Demolition of existing dwelling & the erection of 7No. residential dwellings, with associated parking, amended access location from Lime Tree Close & landscaping.

Scorton 9 Lime Tree Close East Preston

Thank you for your internet representation made on 28th April 2018 which has been recorded as **'an objection'** with the comments as follows:

The Pure Group
Limetree Close East Preston
Plot 4: Limetree Cottages. Proposed Elevations, Floor Plans, Roof Plan & Section
Drawn by: AM The Pure Group
Drawing ref: LTC.PLOT4.001
Planning Issue: March 2018. Scale as Bar
www.thepuregroup.info

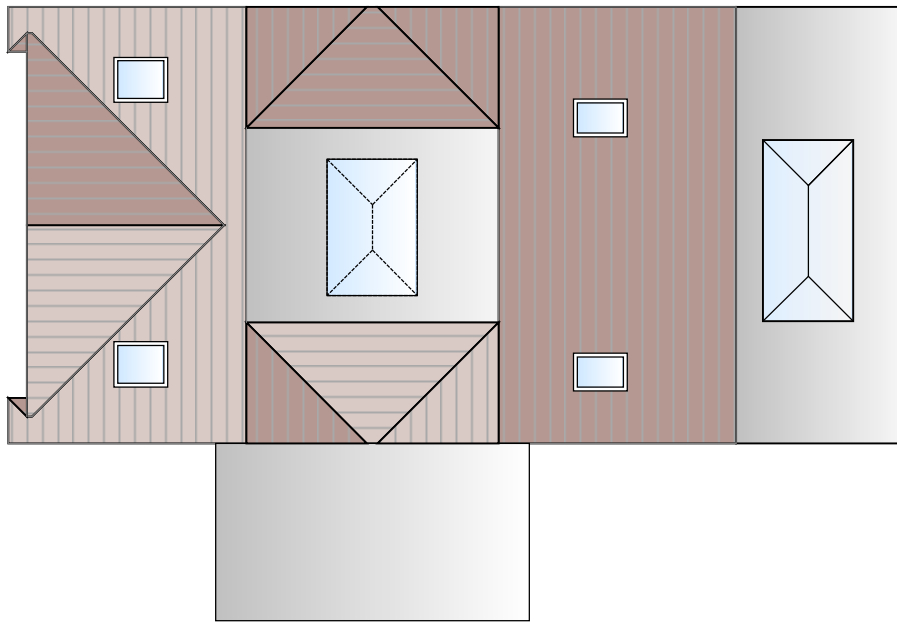
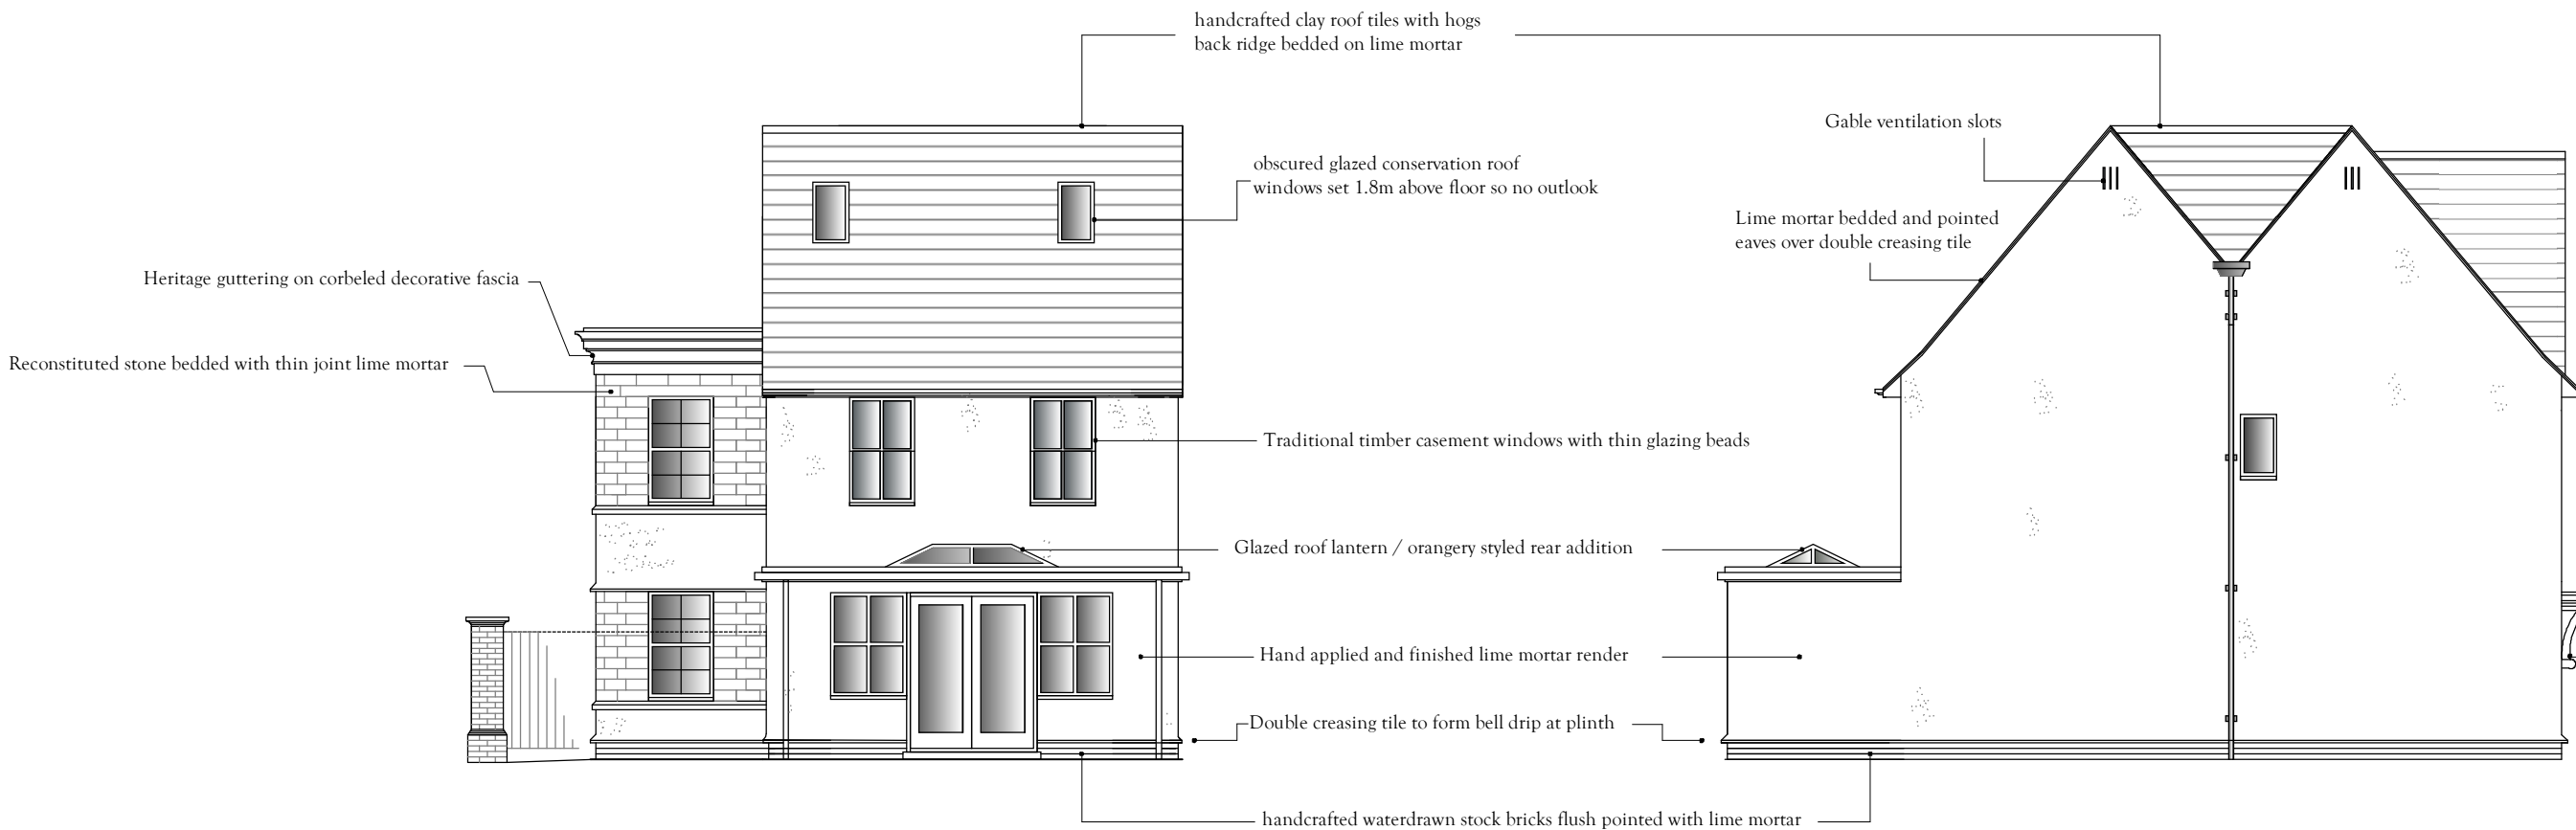
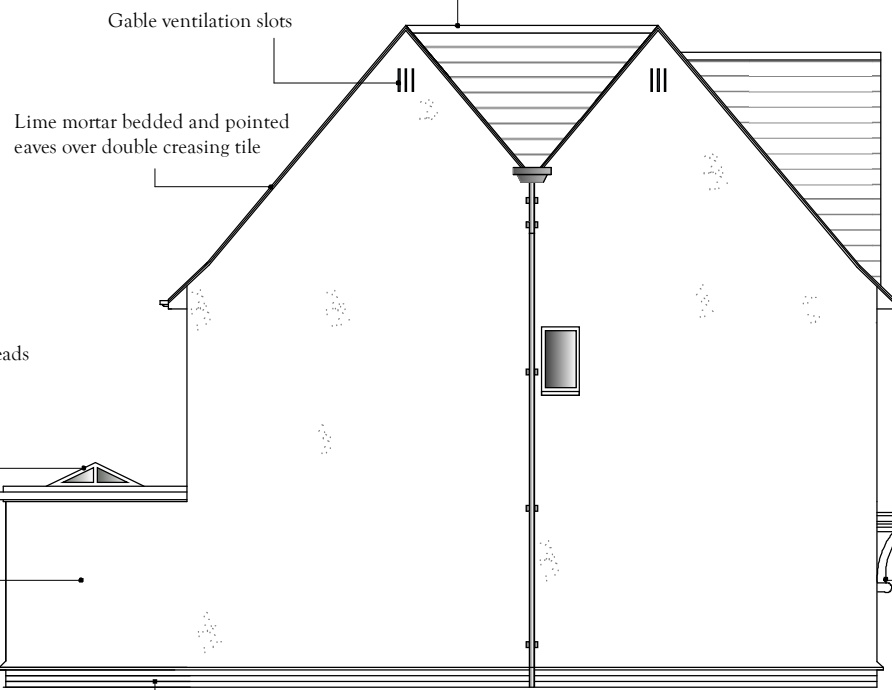
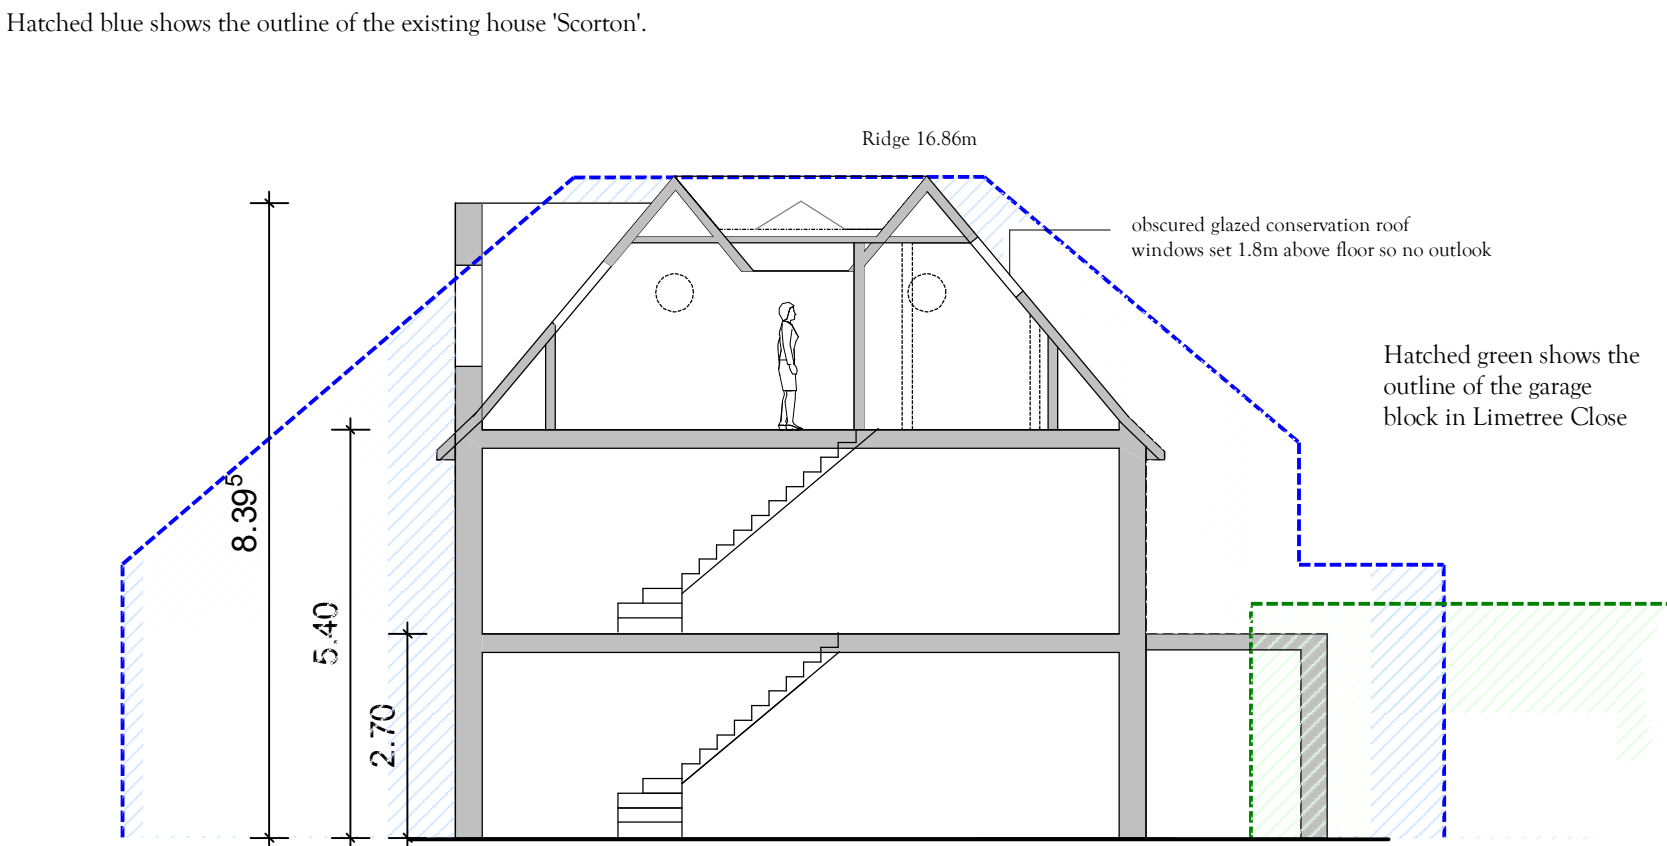
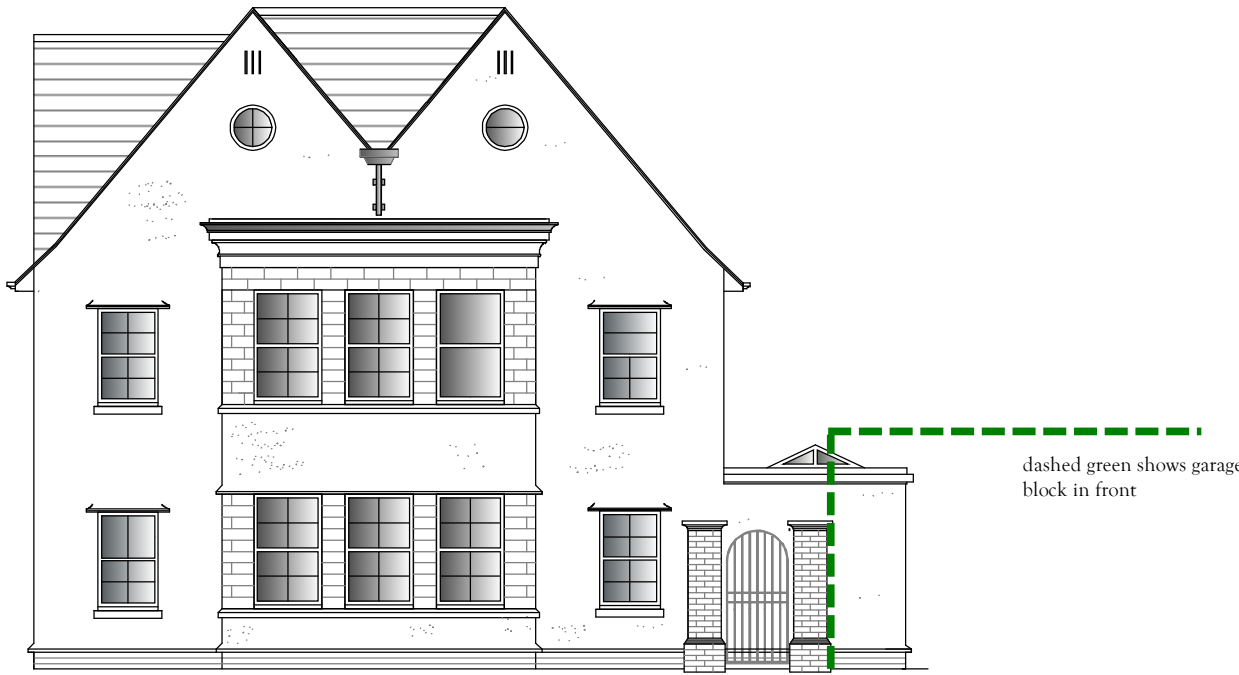
Comment 2. We note from the wording on the plans that the developer assures us the proposed new houses will be the same distance away from the boundary as the existing house, and be the same height. However - the plans show three storey houses with windows in the roof level. Currently our rear garden is not overlooked by the existing old house yet this proposal seems to show a row of four new houses with 2nd floor windows able to look down on us.
